2023/0209

Replacement of the existing telecommunications rooftop installation with a 20m 'streetworks' designed mast with 12 antennas and 6 ground based antennas within a secure compound

The Thurnscoe Hotel, Telecommunications Station Orange, Houghton Road, Thurnscoe

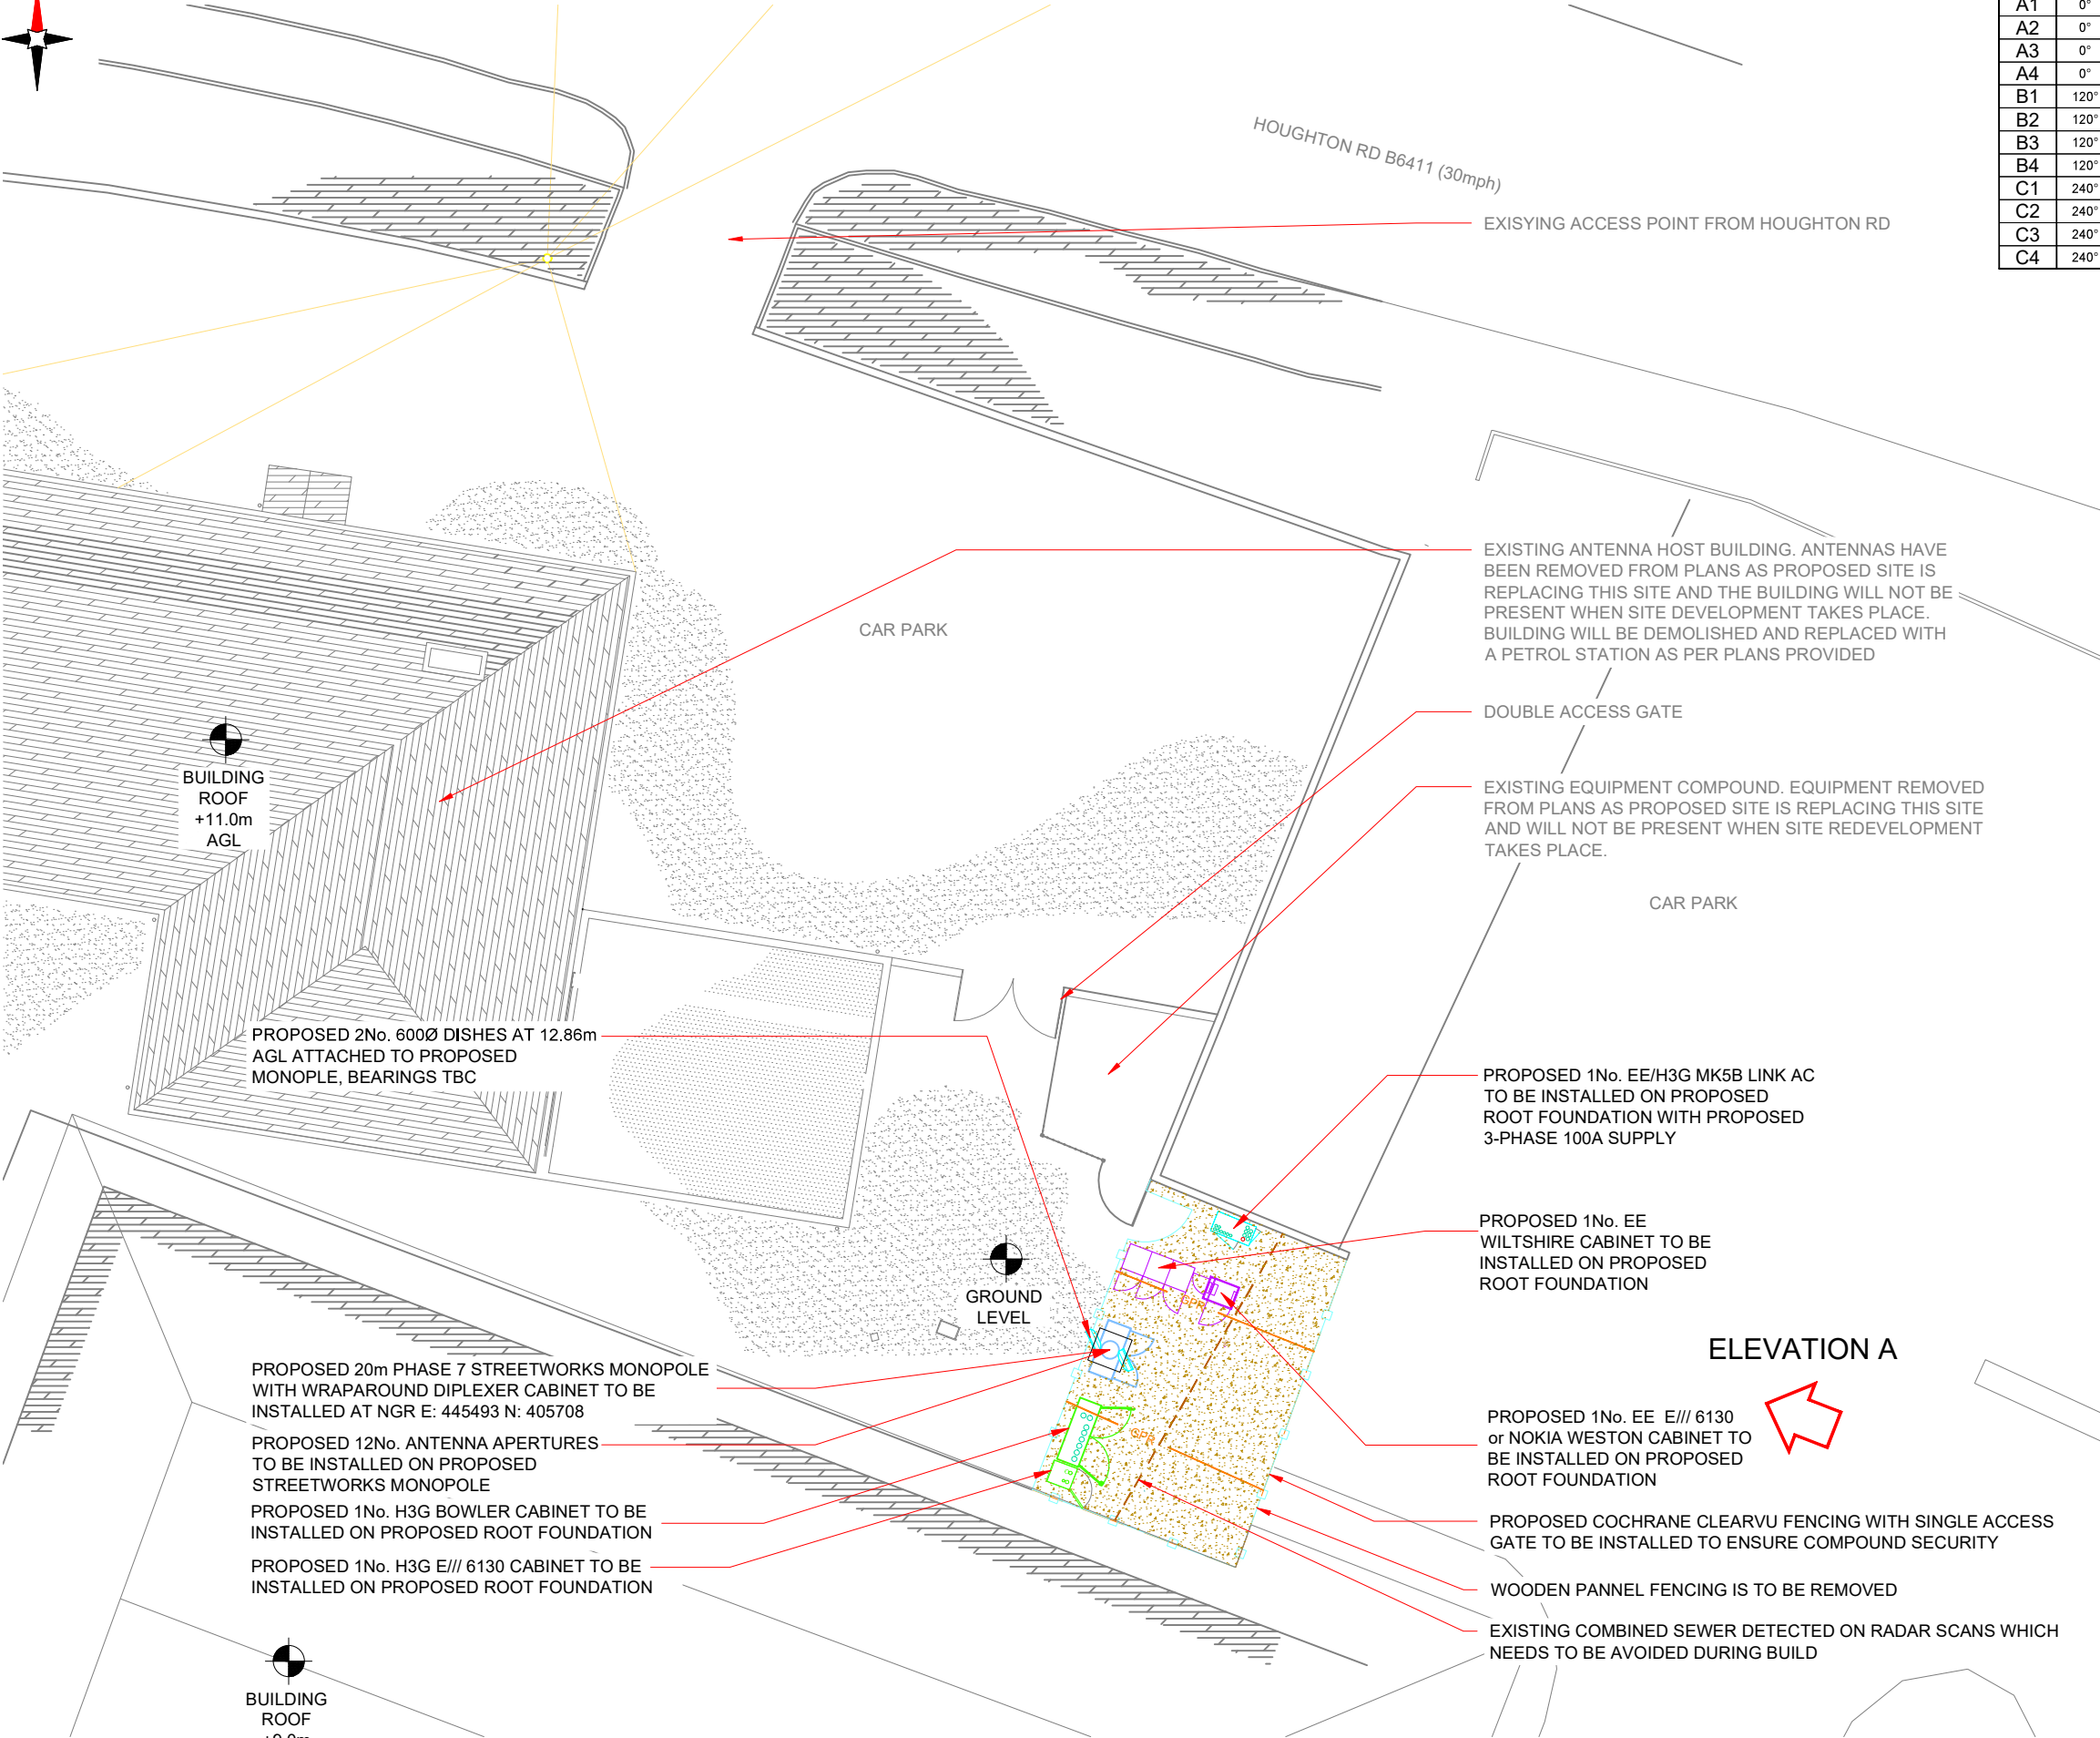
The prominent siting and appearance of the mast were the main reason why the previous application (2021/1619) was refused and dismissed at appeal. The previous siting was close to the road and would be easily seen from traffic and pedestrians heading along Houghton Road. The revised siting is now approximately 30m back from Houghton Road, closer to where the existing telecommunications apparatus are on the building, and backing onto the Asda store roof. It is therefore acknowledged that it is in a less sensitive position and relates better to the positioning of the existing apparatus and will therefore not be as prominent a feature in the street scene compared to the previous application.

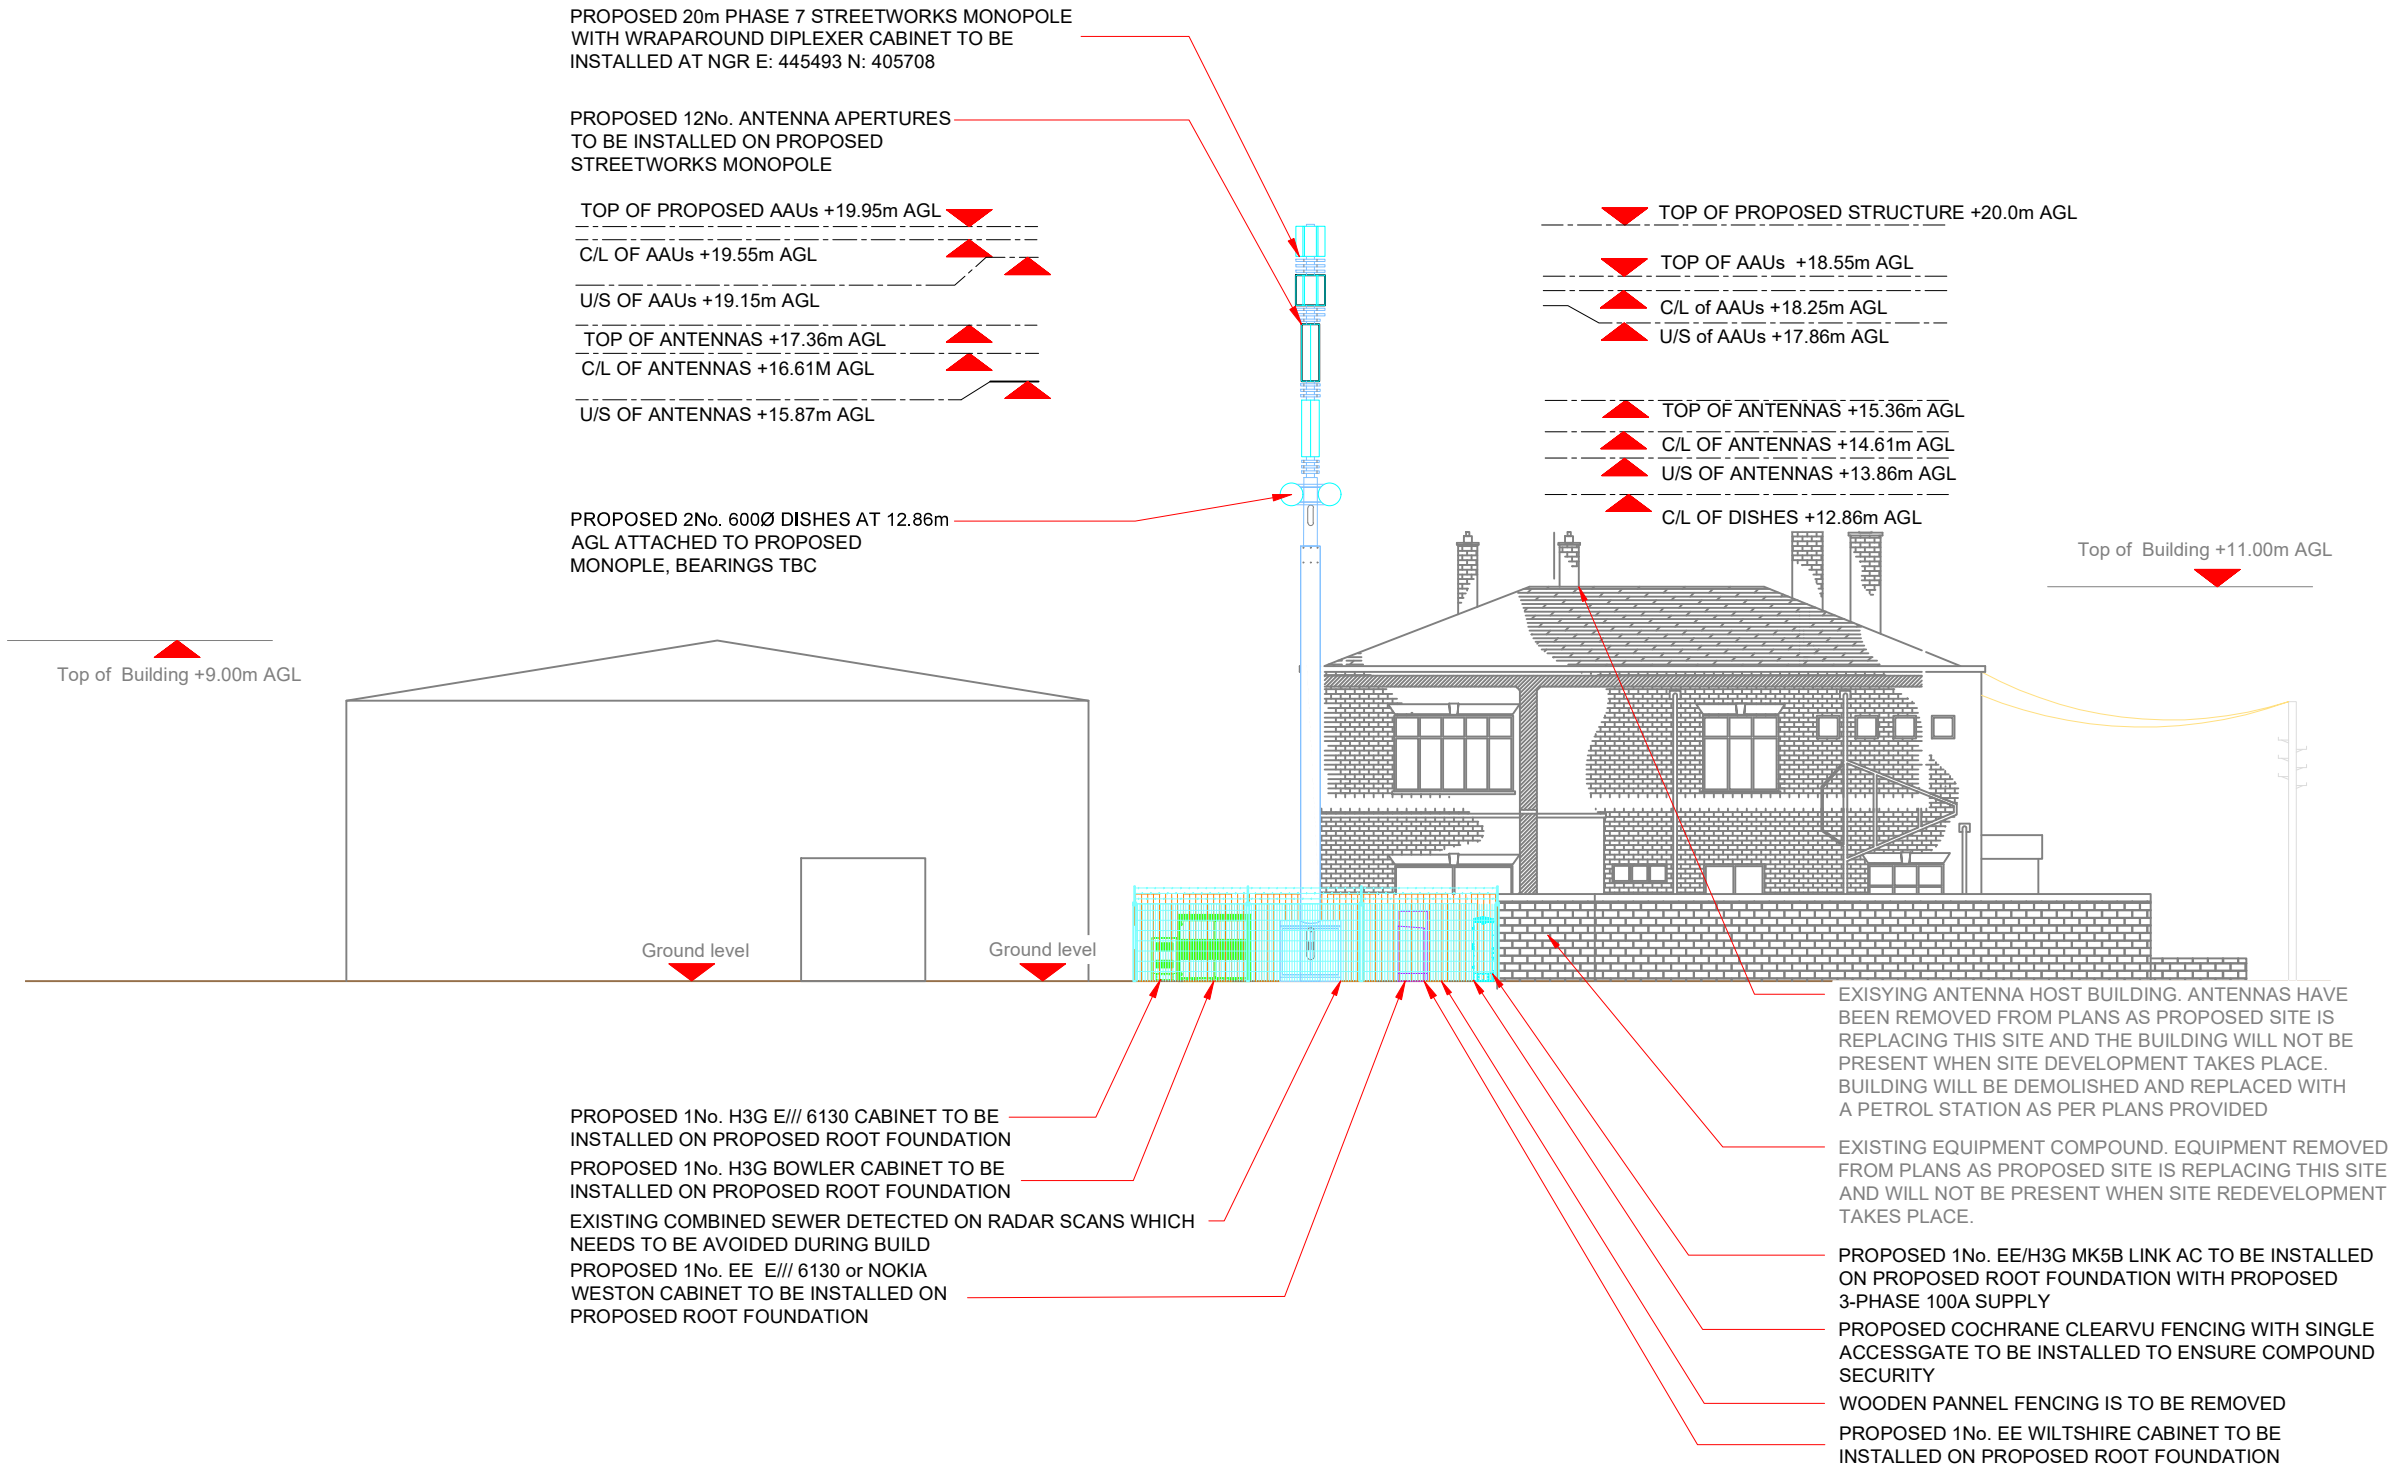
Whilst it is appreciated that the proposal has been designed as one of the thinner options for such 5G telecommunications monopoles, the monopole is still a large structure at 20m in height. There are other vertical elements within the street scene such as lampposts, the proposed pole would exceed the height of these. However, having been set back from the road by 30m the mast would be less prominent on the Houghton Road streetscene compared to the previous refusal. There are also other factors to take into account which are:

The siting of the mast is considered acceptable and its slimline appearance is also considered acceptable. It would be preferable to have the height a few metres less but the applicant has stated it is needed at this height to take on all the equipment, meet 5G capabilities, and prevent the need for any other masts or installations in the area. As commented by the Inspector on the previous decision, the main impact is on the immediate area rather than long distance views. In this respect the siting of the mast back 30m from the road reduces its impact on the streetscene where existing 12 to 15m high streetlights are in existence on the roadside. From an eyeline level it is therefore unlikely that a reduction in height by a few metres would make a significant difference. On balance it is considered that the revised siting, has overcome the previous concerns and the proposed siting, design and appearance of the mast are acceptable.
